# CITY OF ALBUQUERQUE

10-23-23

**Re: Roses Southwest Papers**  
**No address- UPC 101605227405540202**  
**Traffic Circulation Layout**  
Engineer's/Architect's Stamp 10-17-23 (Q16-DA5000C)

A1 TRAFFIC CIRCULATION LAYOUT - PHASE 1 ENLARGED
SCALE: 1" = 10'-0"

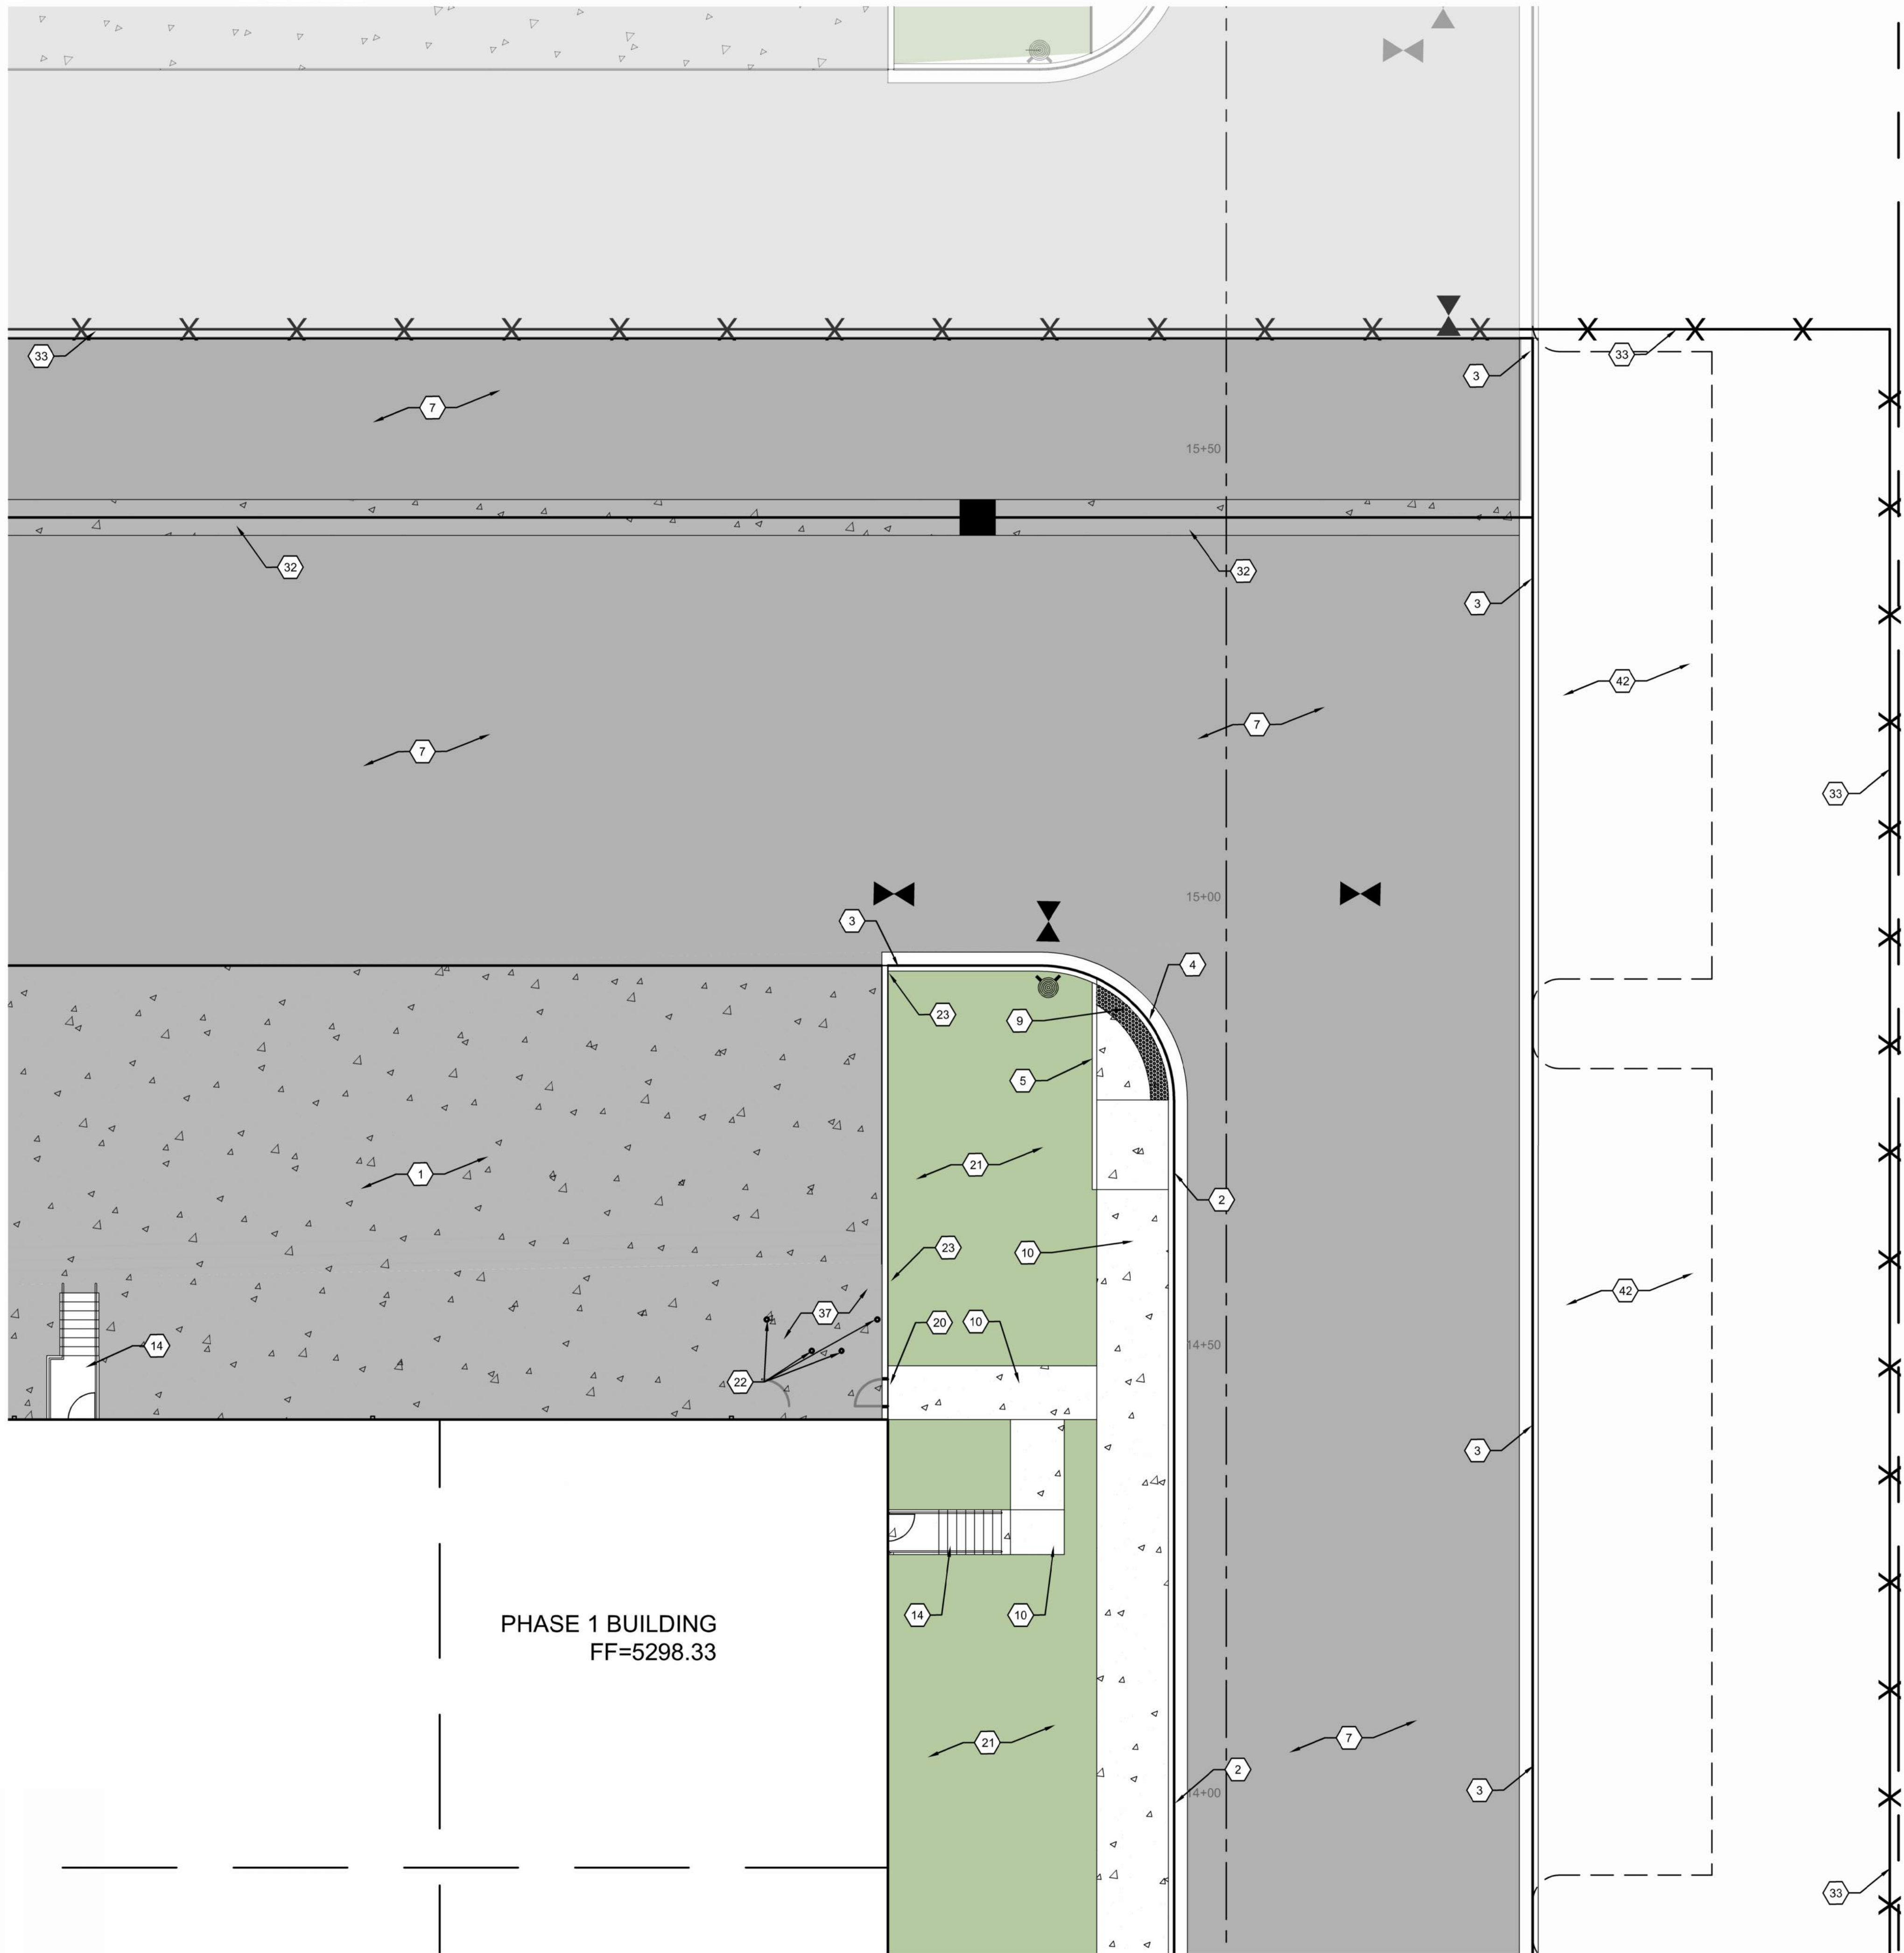
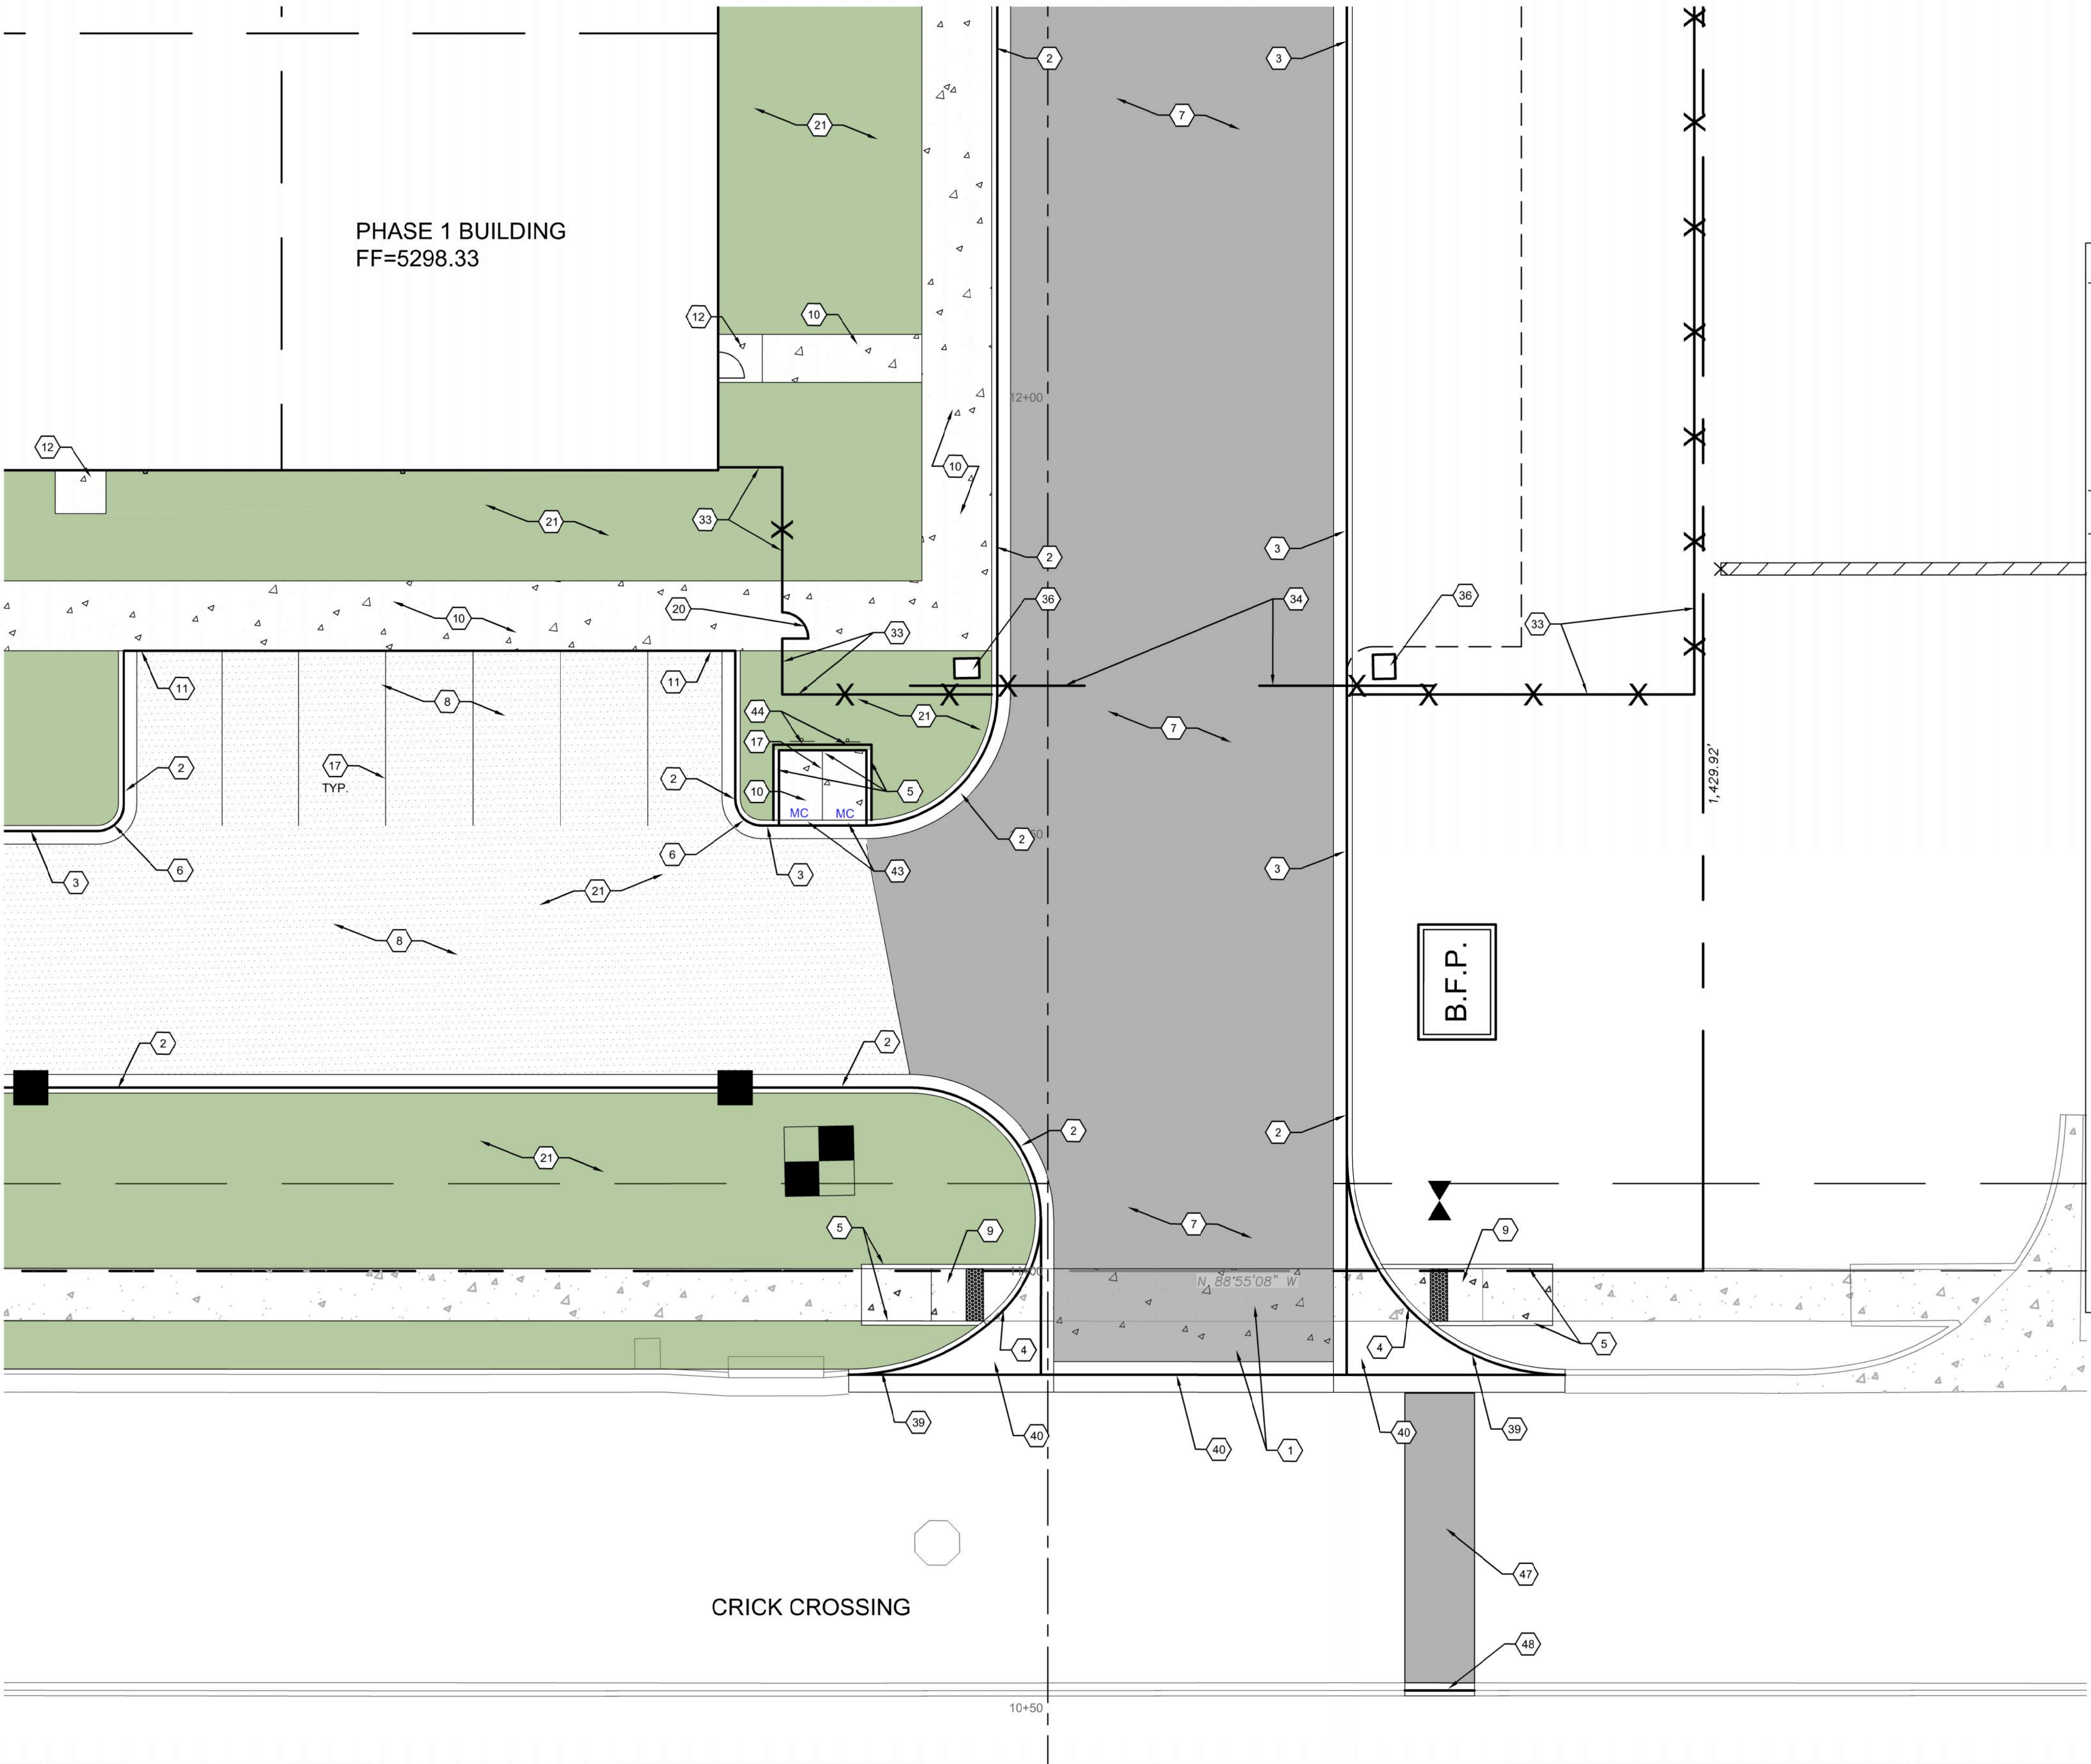
12. On Sheet TCL-1B you are showing a manhole in the center of the valley gutter. It can be difficult to construct the valley gutter invert with the manhole pad/cover (for info only).

13. The driving surface into the MC parking is to be flush with the parking lot. It appears there is a curb. See keyed Note 3.
14. Please show the ADA path across drive entrances Sheets TCI-1D and 1E.

22. Add a note stating "All broken or cracked sidewalk must be replaced with new sidewalk."
23. There are a couple small stumps in the sidewalk near Keyed Note 46 Sheet TCL-1E that should be removed.
